KITTITAS COUNTY COMMUNITY DEVELOPMENT SERVICES

March 12, 2021

RE: Brown and Jackson (File #SE-20-00003)

SHEET NO.
C1.1
201834

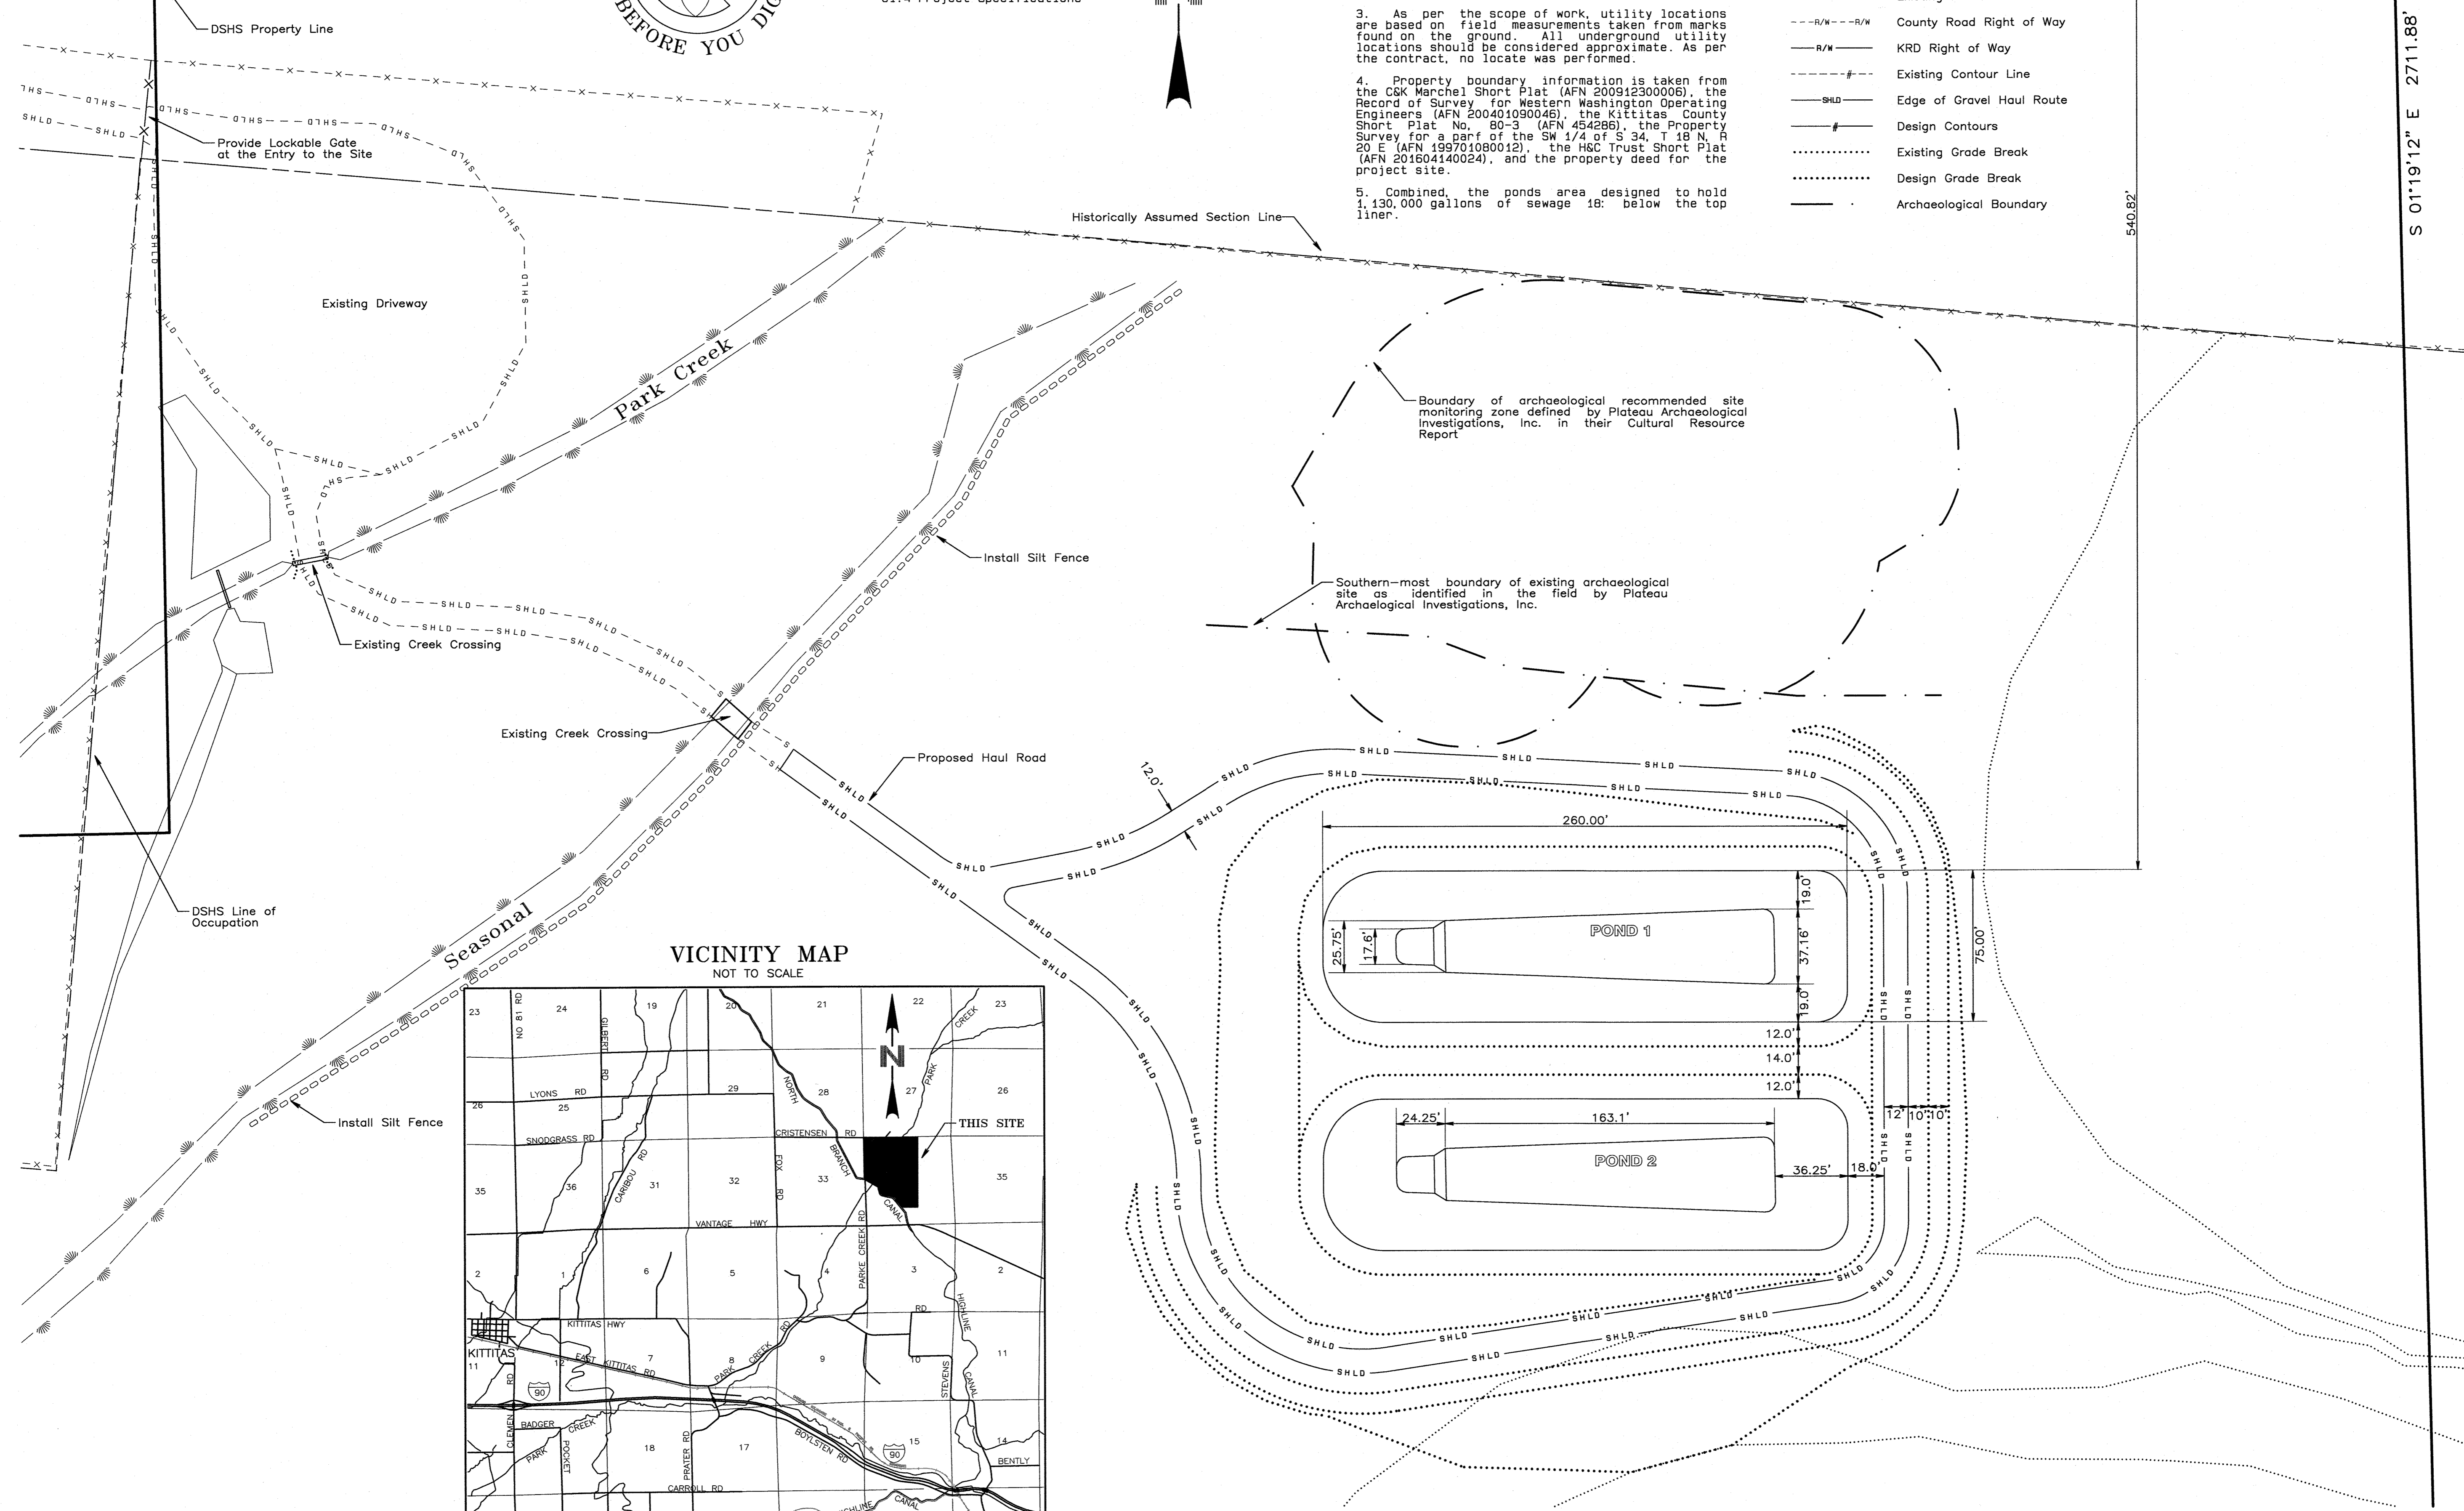
It appears the project includes one fence that sits along the parcel boundary. The adjacent DCYF facility provides a potential interaction with the project area and runaway youth. CDS has concerns with protection for human safety in the event that a youth runs away from the facility, particularly during evening hours where visual cues are limited, and fall into one of the lagoons. A similar concern exists for Wildlife that are able to traverse the property line fences. CDS will require a robust safety plan that accounts for these possibilities.

SHEET NO. C1.2
201834

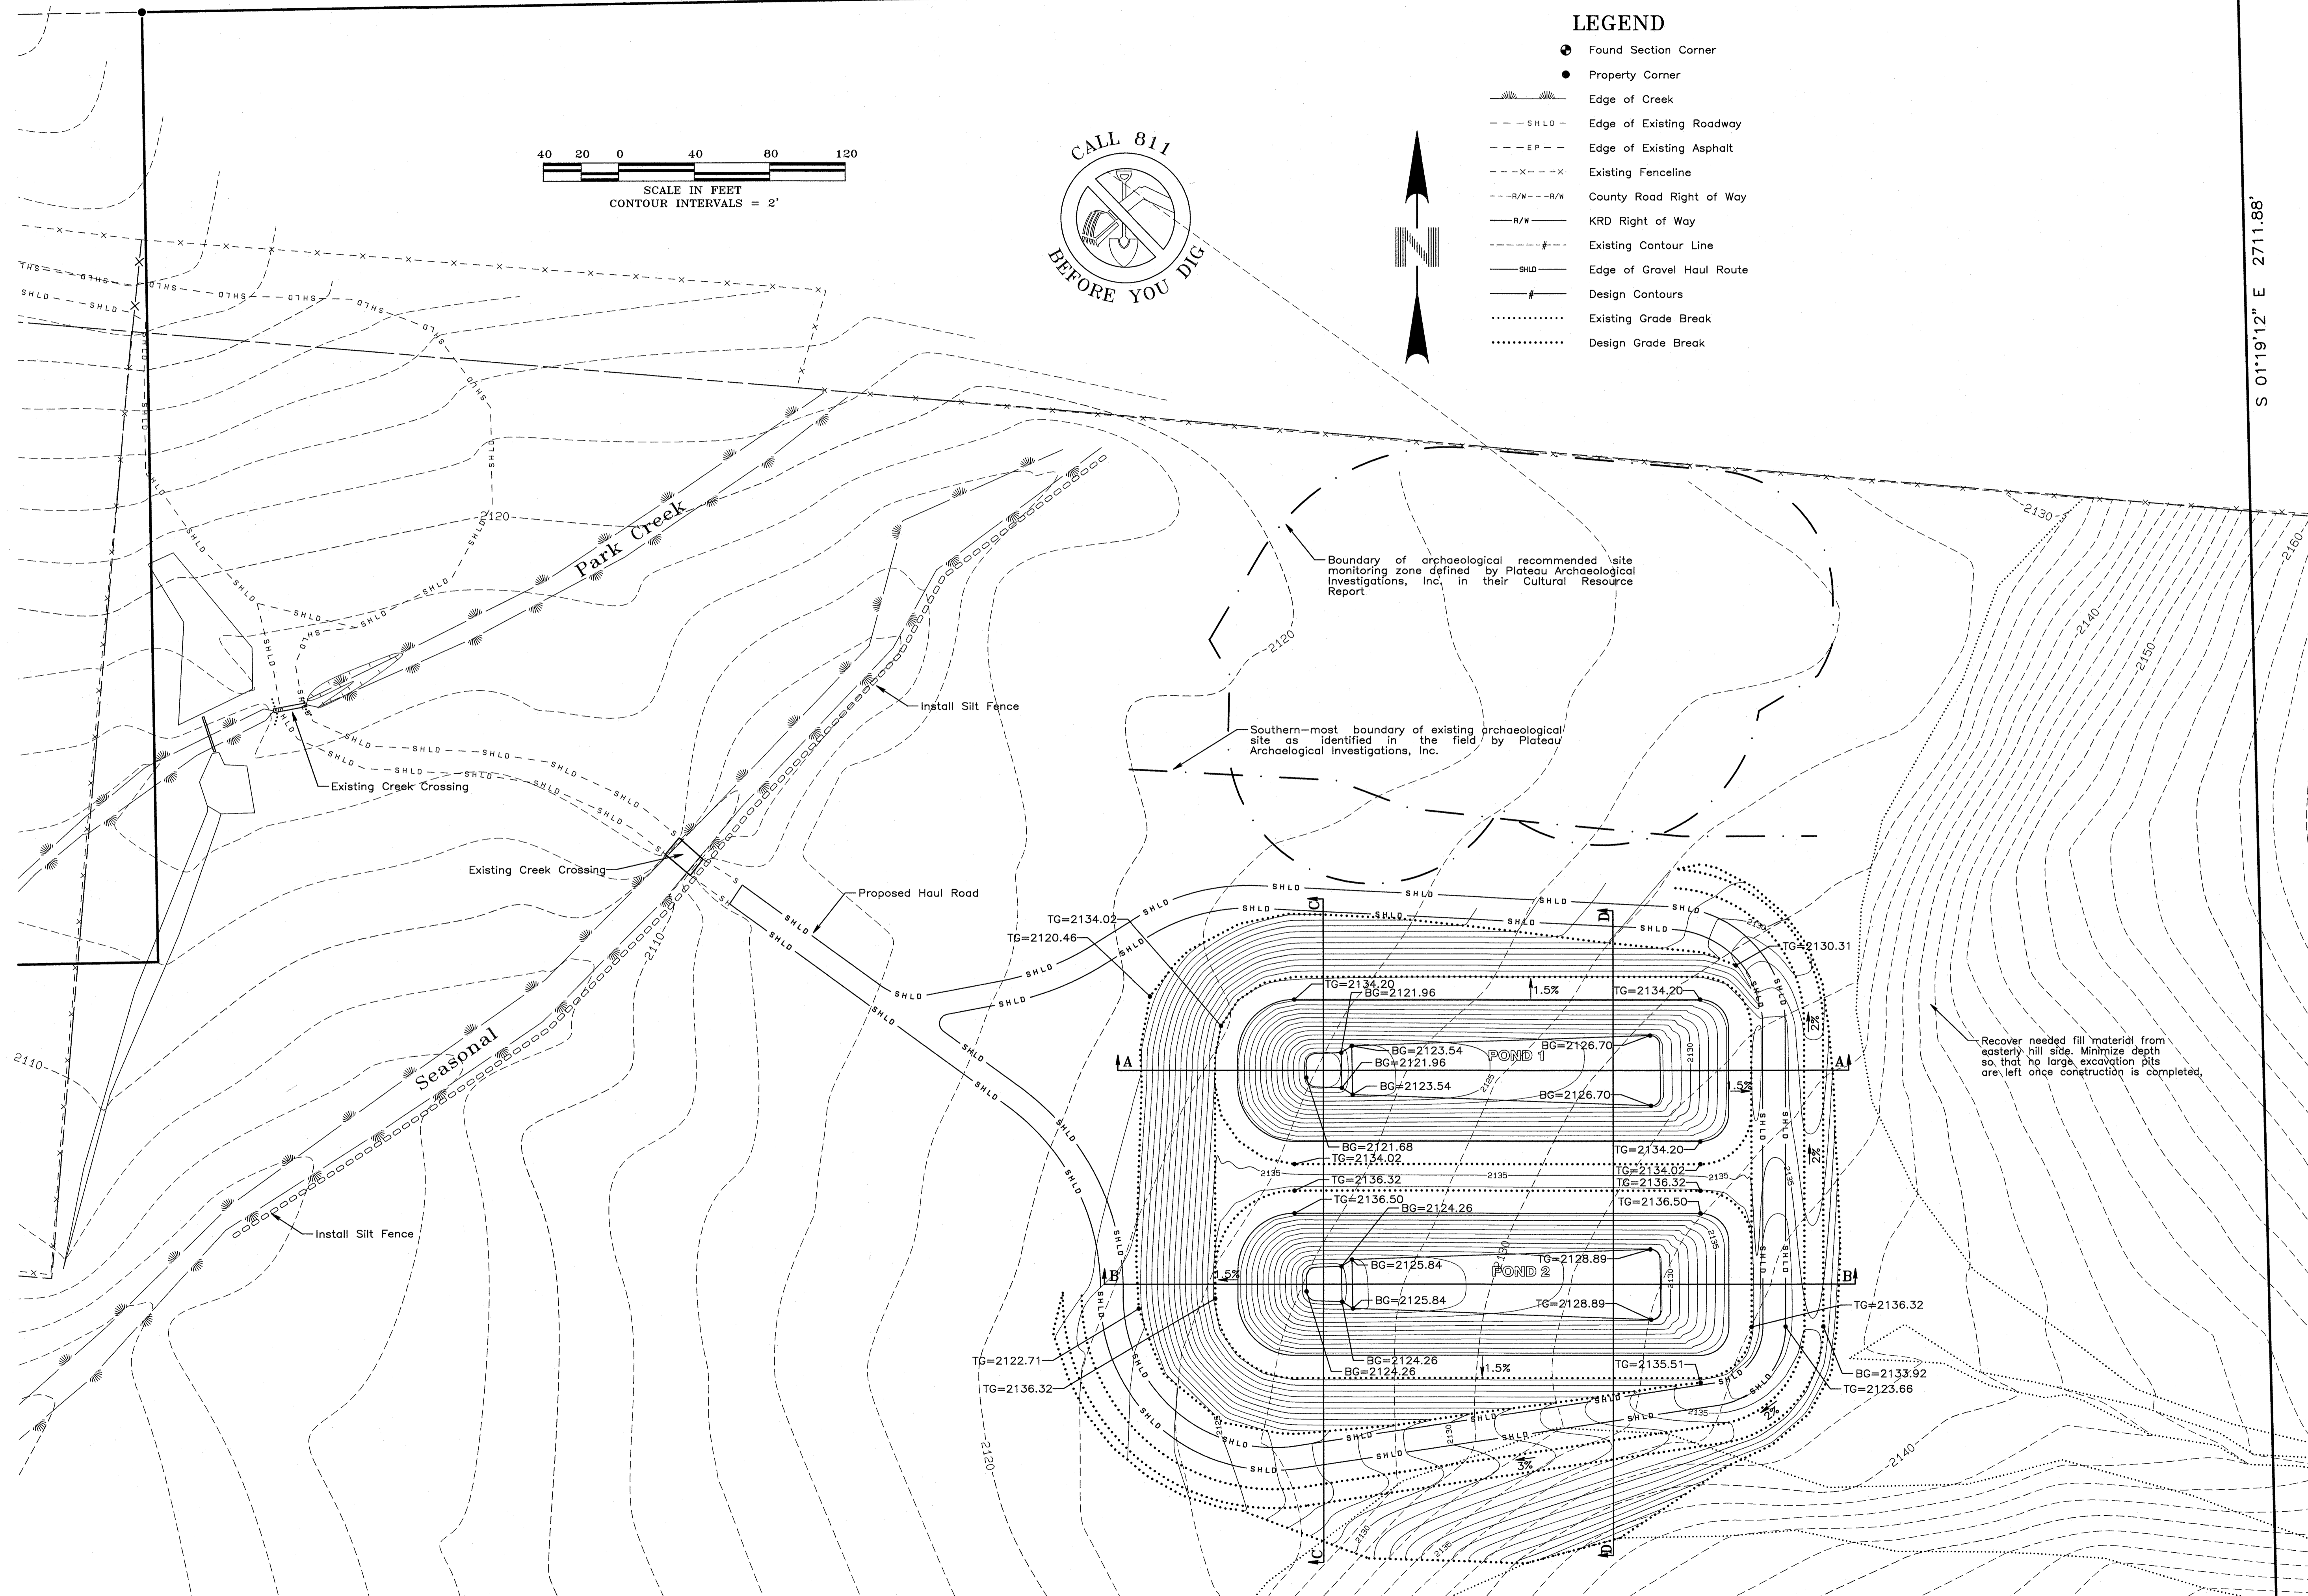
describes these test holes as being dug downslope of the proposed project location which is at a lower elevation than the bottom of the proposed ponds. As ground water levels are not always horizontal, CDS is not convinced this clearly indicates the depth of the ground water at the proposed location. Lagoon infiltration into groundwater could have significant impacts on groundwater quality. More information is needed regarding how the system will prevent any interaction with ground water in the event of a leak or spill. CDS will also require specific information about the location and depth of groundwater at the project site.
